I've received further notification of planning permission application ref 3/2021/0032 giving me the opportunity to make representation by 5th February 2021.

My objections to the plans submitted under ref 3/2021/0032 are as follows:

Drawing Title			
Proposed Eaves Detail			
Project			
2 Pendle Street West, Sabden			
Client			
Jigsaw Homes Group			
Scales @ A2		First Issue Date	Drawn
1:20		06 / 10 / 2020	BB
Job Number / Dwg. No. / Revision		RIBA Stage - Drawing Status	
L2980_GA05_A		[3] - Planning	
Checked		By	
Date		Date

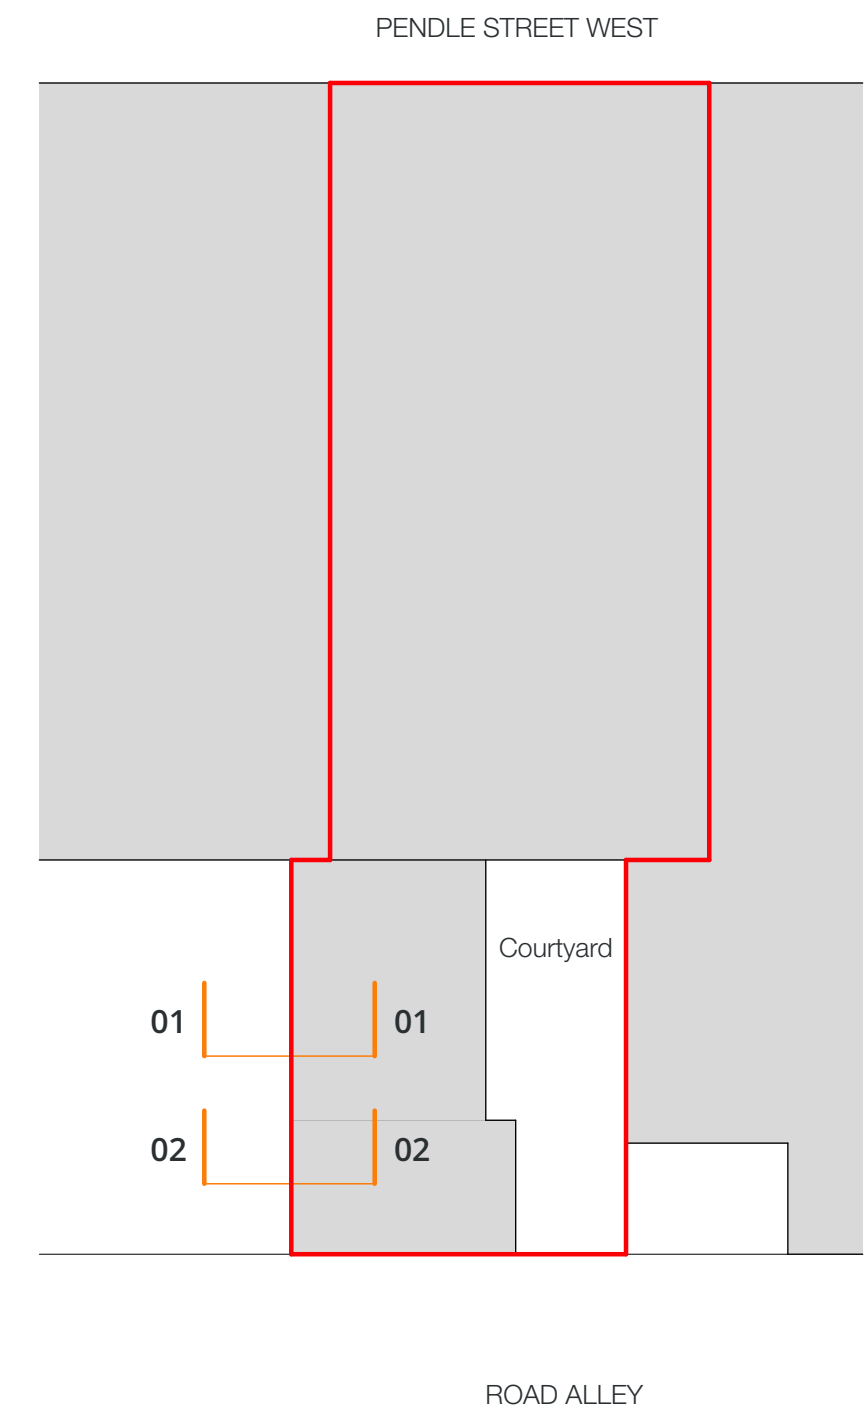
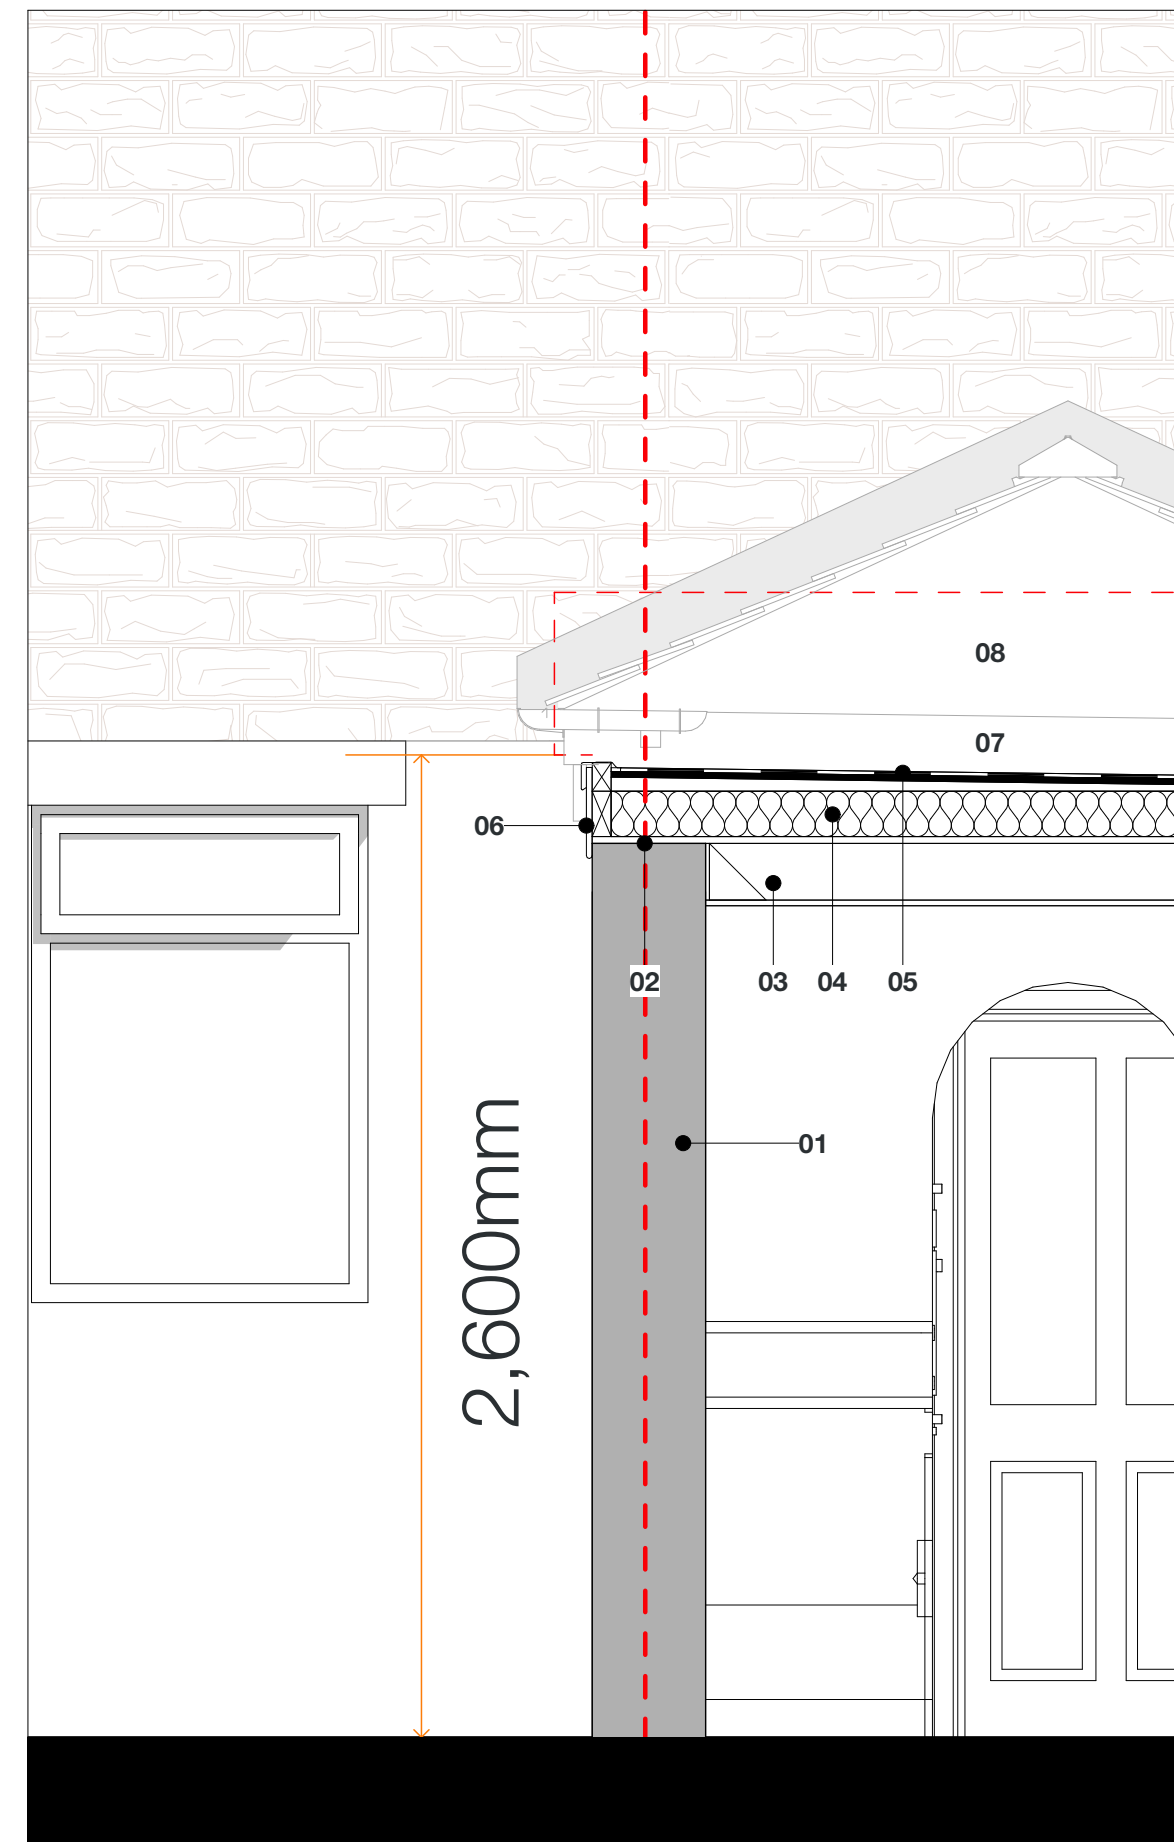
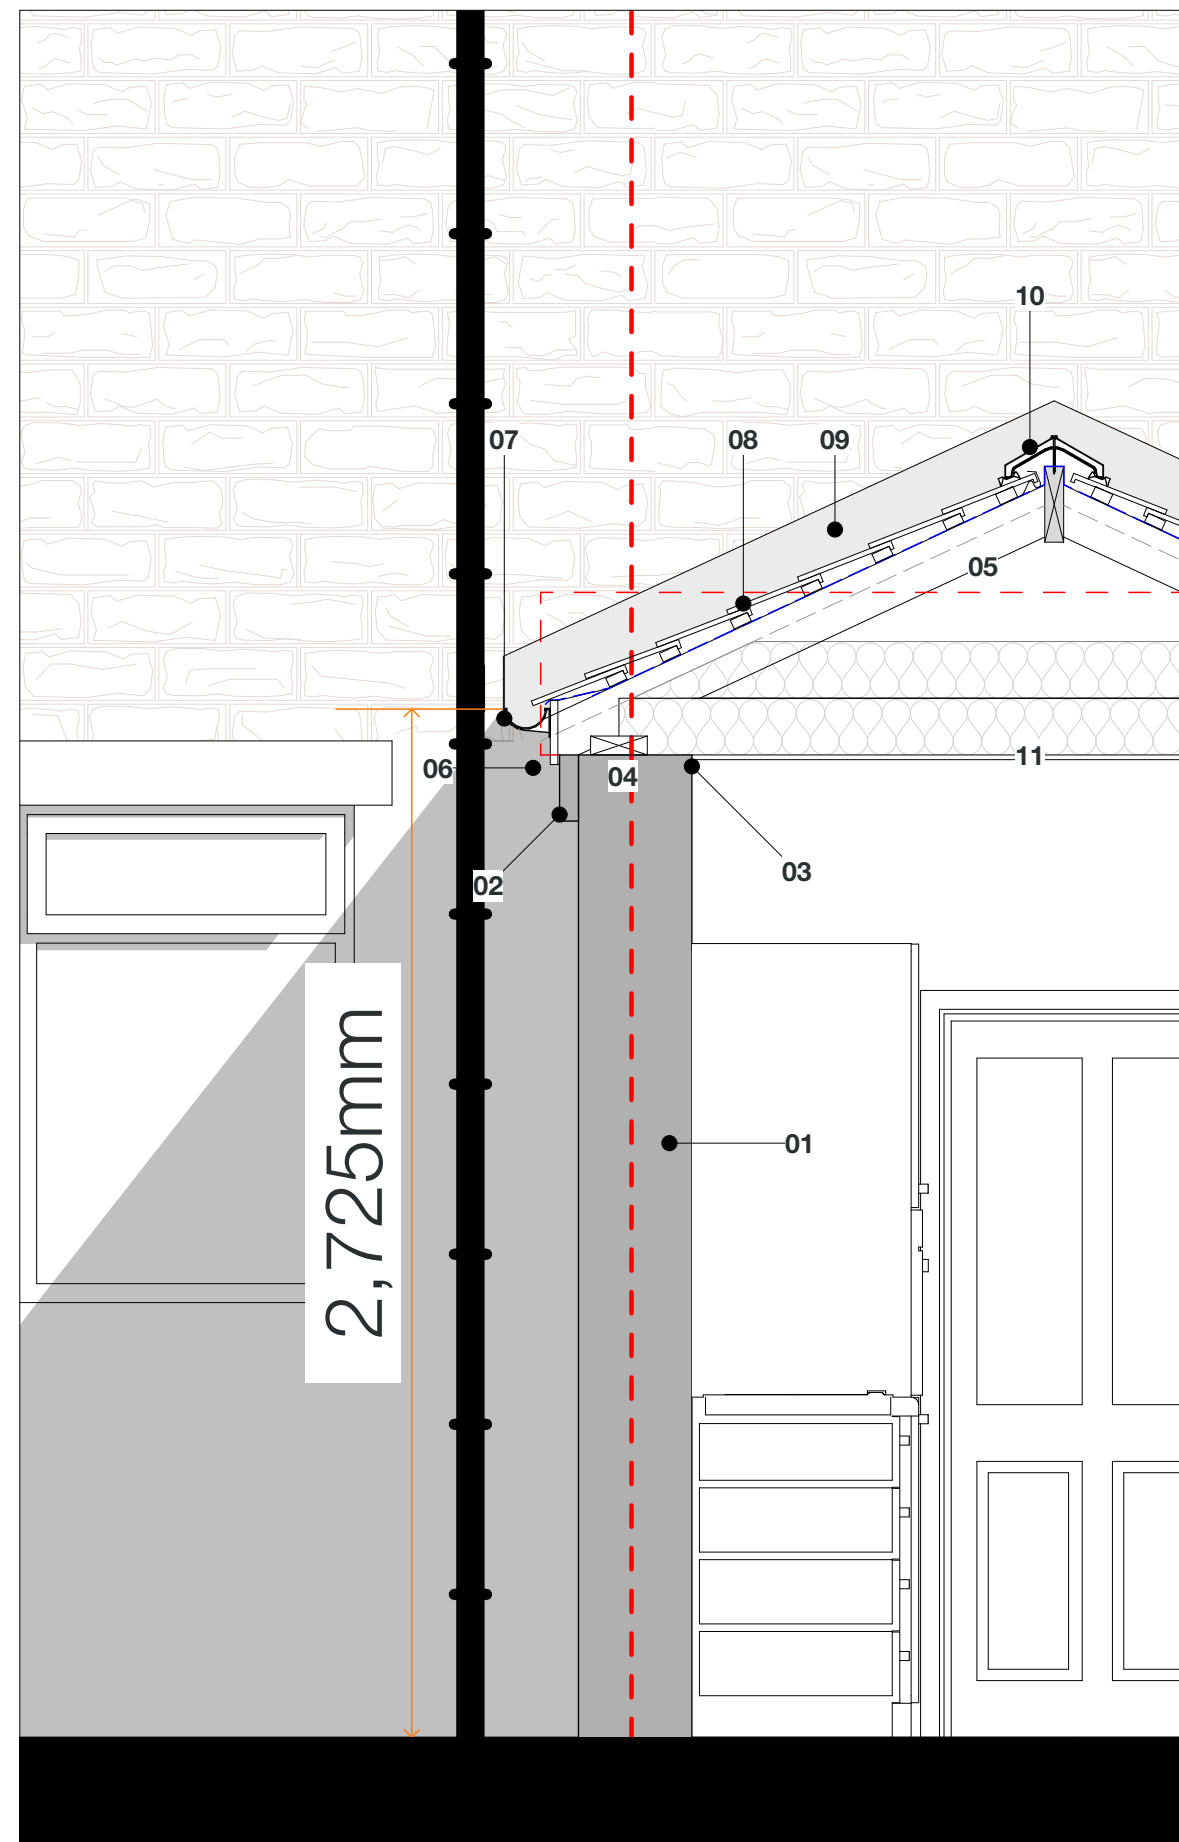
- The applicant proposes to build outside the curtilage of the development site - as the inclusion of fascia and guttering encroaches across the party wall into my airspace, thus resulting in a trespass. I have taken legal opinion and have served notice to the HA that I do not give permission for any overhang across the boundary.

- The applicant proposes to leave the original stone parapet in situ, building above it and therefore leading to the overall height of the roof to be increased from the original, whilst also resulting in a *botched and untidy finish to my side of the party wall. The original stone parapet housed an internal gutter, so there was previously no issue of trespass. I have requested to the HA that this stone gutter is utilised to re-insert an internal gutter system sympathetic with the original plans, and also avoiding any breach of the party wall and any issue of trespass.

Elevation E-01
Proposed Party Wall Elevation

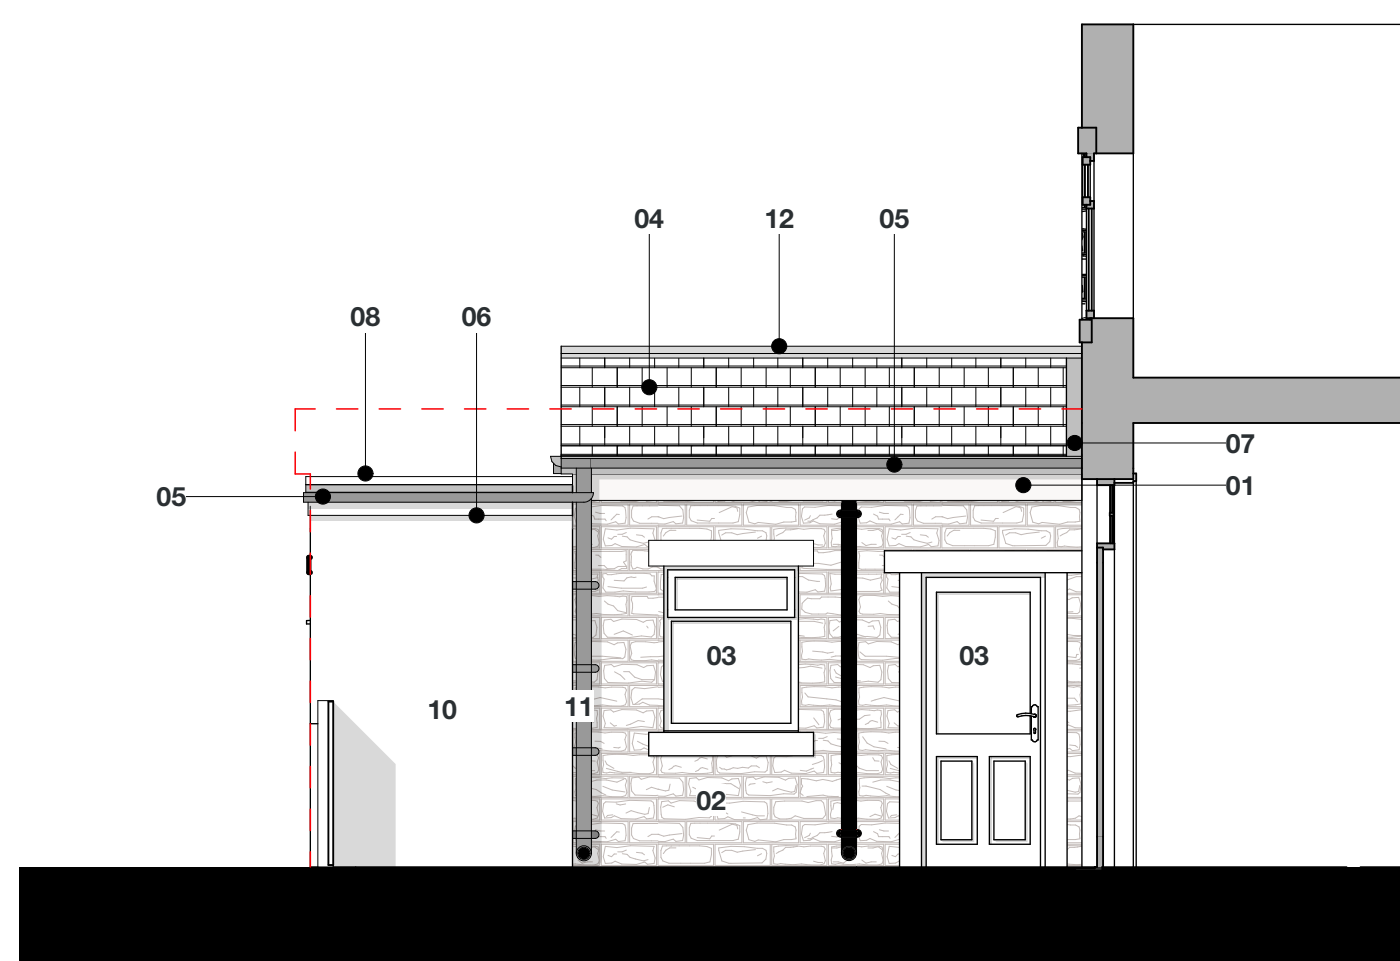
security, installing a roof out of keeping with the area of natural beauty and adjoining properties, trespassing into my airspace, failing to make good the area where they have increased the height of the original flat roof.
